**SILVERTOWN TUNNEL DCO
WRITTEN REPRESENTATION BY NATHANIEL LICHFIELD & PARTNERS
ON BEHALF OF U AND I GROUP PLC**

We have consulted with TfL throughout the emergence of the proposals and have made considered representations at each stage. U+I has no objection in principle to the proposed scheme. It does, however, object to the detailed arrangements proposed for accommodation works on and around Tunnel Avenue (which provides the main access to Morden Wharf).

**PLAN**  
SCALE 1:250 @ A1

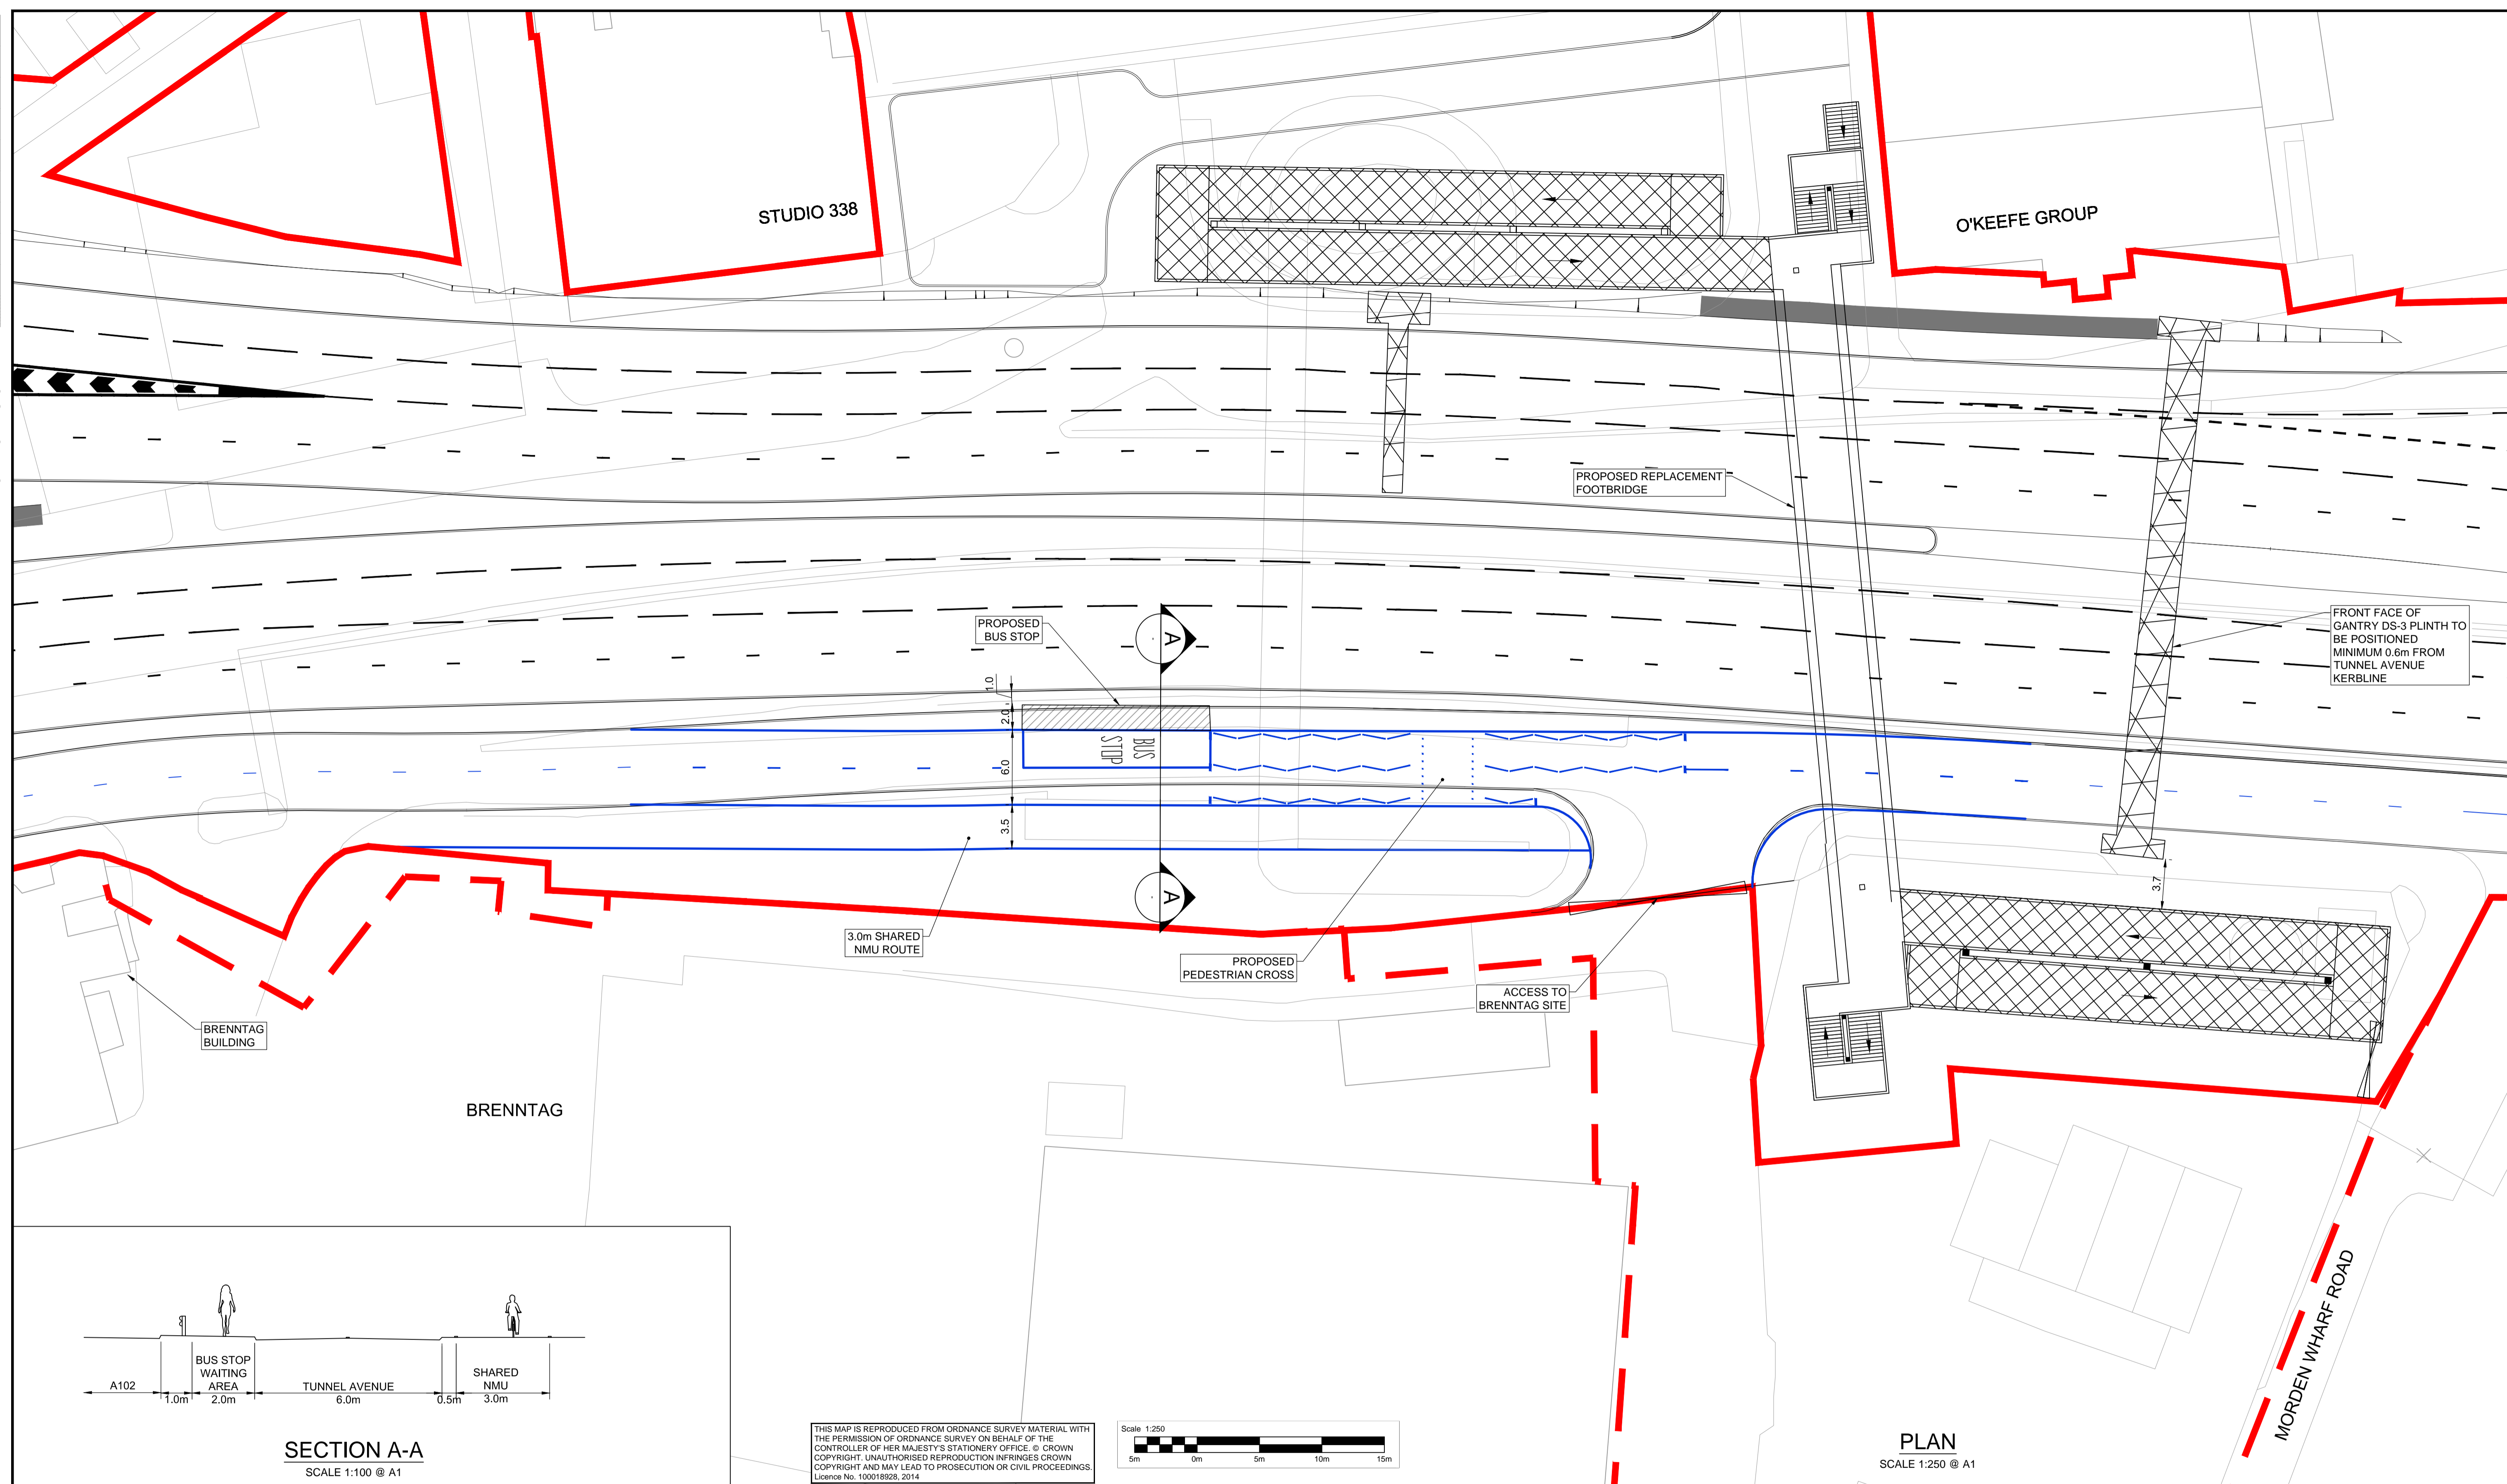
In respect of bus provision and in the light of the wider objective to encourage public transport usage, there should be provided sufficient and adequate bus stop facilities on Tunnel Avenue (for both southbound and northbound journeys) to serve those businesses and homes, without impinging on pedestrian and cycle routes.

The Ramboll report submitted to TfL in September 2015 therefore recommended providing appropriate means of allowing for the stopping of buses on Tunnel Avenue whilst maintaining cycle and pedestrian safety. Whilst this is important for northbound movements, for which the existing footway is too narrow, it is even more important for southbound movements for which there is no footway at all.

The Policy 6.1 also requires under criterion j) that all parts of the public transport network can be used safely and easily, which the scheme also fails to do by not providing scope for safe southbound bus stop(s) on Tunnel Avenue.

The current detailed design of the DCO scheme for Tunnel Avenue does not provide adequate width for safe use by cyclists and pedestrians. It leaves no scope for provision of bus stop(s) for southbound bus services, other than in a very dangerous and inadequate manner. It creates danger for cyclists needing to connect between the Tunnel Avenue carriageway and the new pedestrian/cycle shared surface overbridge. None of these matters can be dealt with by traffic management measures.

- a) clear patterns of safe pedestrian and cycle connections between Tunnel Avenue and the new share surface overbridge
- b) provision of a safe northbound and southbound bus stop facility close to the overbridge to encourage public transport access for the new homes and jobs on the western side of the Peninsula.
